ENVIRONMENT PROTECTION AUTHORITY

RE: Proposed Stage 1 development of Kings Forest, Tweed Shire Council LGA, MP08_0194

ATTACHMENT 1: RECOMMENDED AMENDMENTS TO THE PROPOSAL

Figure 5 – Proposed works in buffers and 7(a) and 7(l) zones (Source: Mortons Urban Solutions)

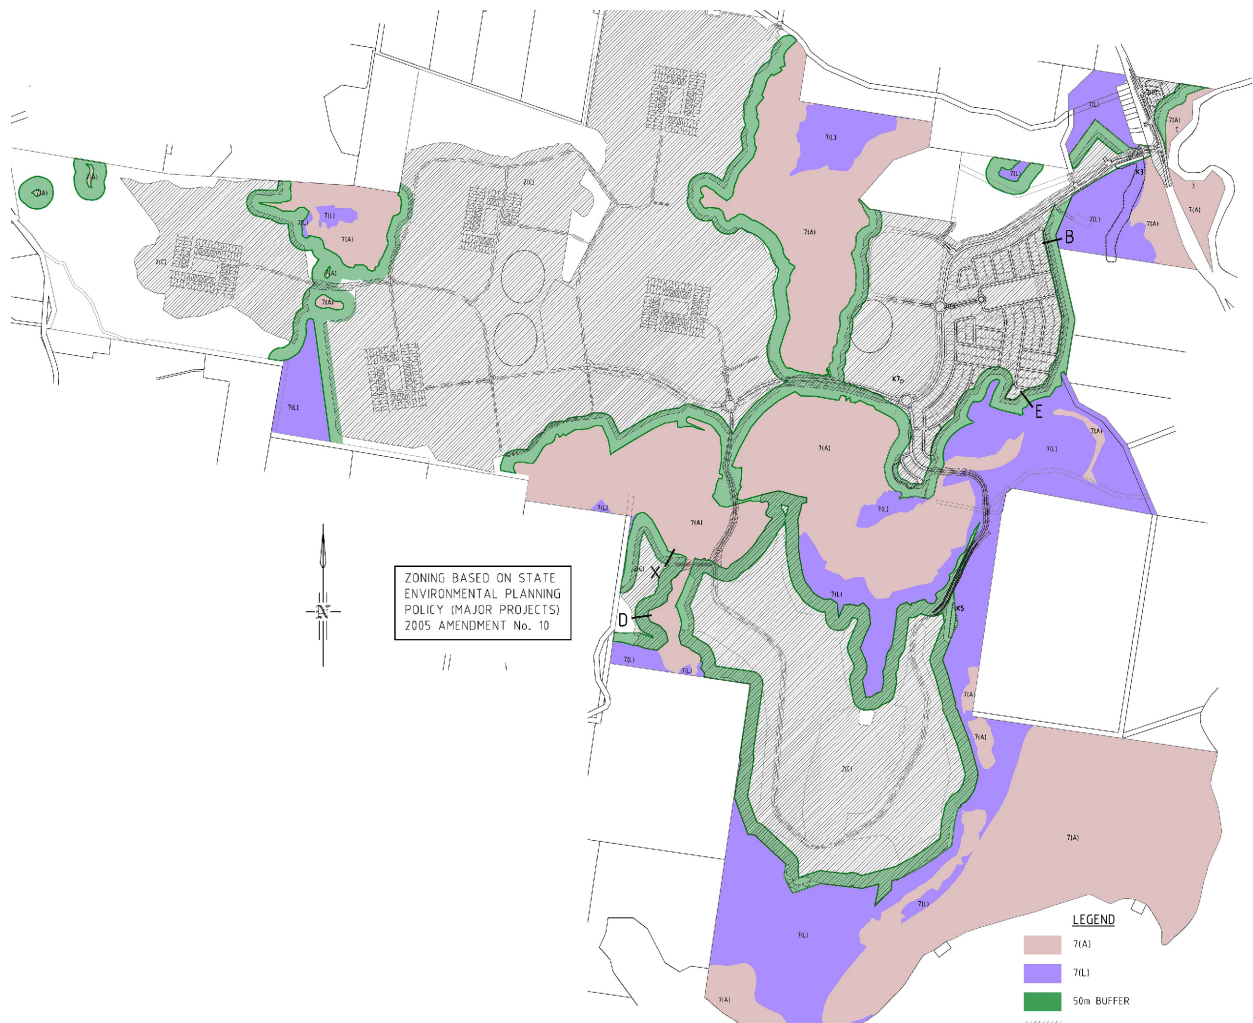
The current proposal, however, seeks to divide the 50 metre buffer zone into two distinct zones: an *inner* 30 metre and an *outer* 20 metre buffer zone. The Buffer Management Plan (BMP) depicts a 'landscaped drainage corridor' (Figure 13B) being part of the vegetated inner 30 metre ecological buffer, while the same plan indicates that all vegetation would be removed from the outer 20 metre ecological buffer along with approximately 10 metres of the 30 metre inner buffer zone (3.3 and Figures 14, 14A and 14B). While it is acknowledged that the CPA provides for the use of *some* areas of the buffer for infrastructure and clearing, *subject to approval* in each case, the current proposal is not considered consistent with the CPA and does not provide adequate protection for the adjacent ecological values.

The proposed use of the outer 20 metre zone *entirely* for development purposes such as roads, footpaths, APZs for fire and placement of a Koala fence on the eastern edge of the swale through the Precinct 5 buffer (and elsewhere) is regarded as being equivalent to the broad scale reduction of the buffer from 50 metres to 30 metres. In the case of the Koala fence, the EPA notes that it would require cleared breaks for physical separation to Koalas, as well as for monitoring and maintenance. Should a further six metre APZ be provided under the *Rural Fires Act* to protect this asset (discussed below in relation to Koala plan of management), the inner buffer would be reduced to 24 metres of vegetation for the majority of Precincts 1 and 5.

EPA submits that the current proposal and design of APZ, roads, footpaths, bio-retention swales and koala fencing are largely inconsistent with the intent and purpose of the 50 metre EPZ. The proposed buffer for Precinct 5 adjoins ecologically significant lands including Nature Reserve, SEPP 14 wetlands and Endangered Ecological Communities (EECs). If approved in its current form the current proposal would also create a concerning undermining precedent for future development within ecological buffers of this kind.

As such, the EPA does not agree that the documents demonstrate (under C20) that clauses 7 or 8 of Schedule 3 of the *State Environmental Planning Policy (Major Development) 2005* have been adequately addressed. The EPA recommends that all bushfire APZs and roads, for example, be provided for from within the approved development footprint, unless there are compelling ecological reasons presented otherwise.
